Our Ref: AL/75/19/PL

**Town & Country Planning Act 1990 (as amended)
Town and Country Planning (Development Management Procedure) (England) Order 2015
Application for Planning Permission**

Development Construction of 8 no. dwellings, alterations to access and associated works - This is a Departure from the Development Plan

Location Bridge Cottage Lidsey Road Bognor Regis

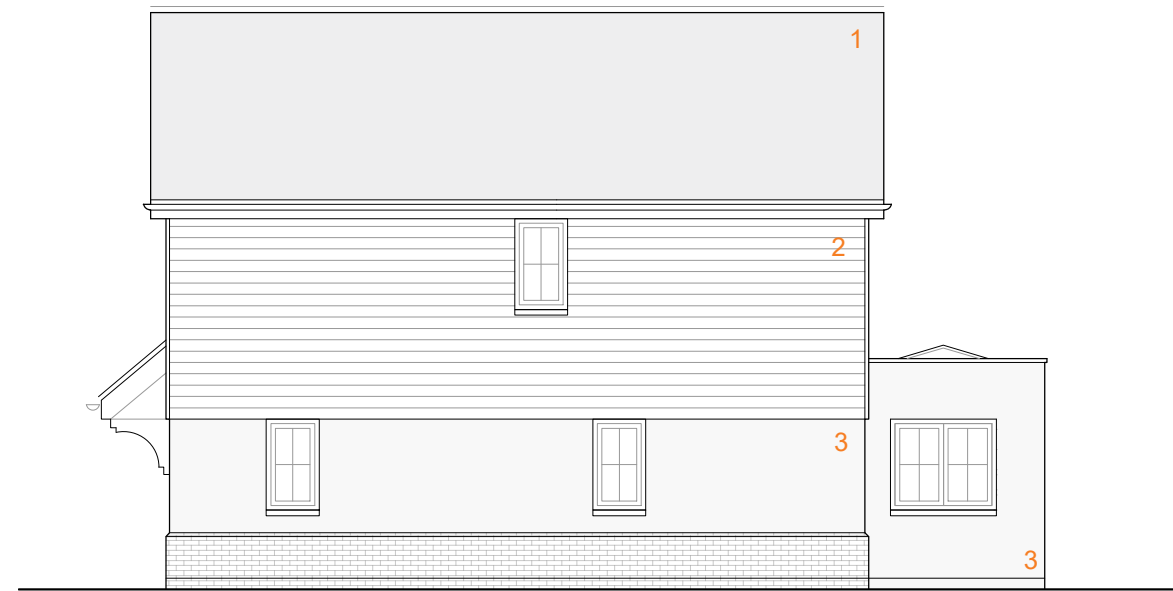
Drawing number 1042/SK10 & Sk11 do not accord. The floor plan is missing a window that is shown on the side elevation. Please forward amended plans accordingly
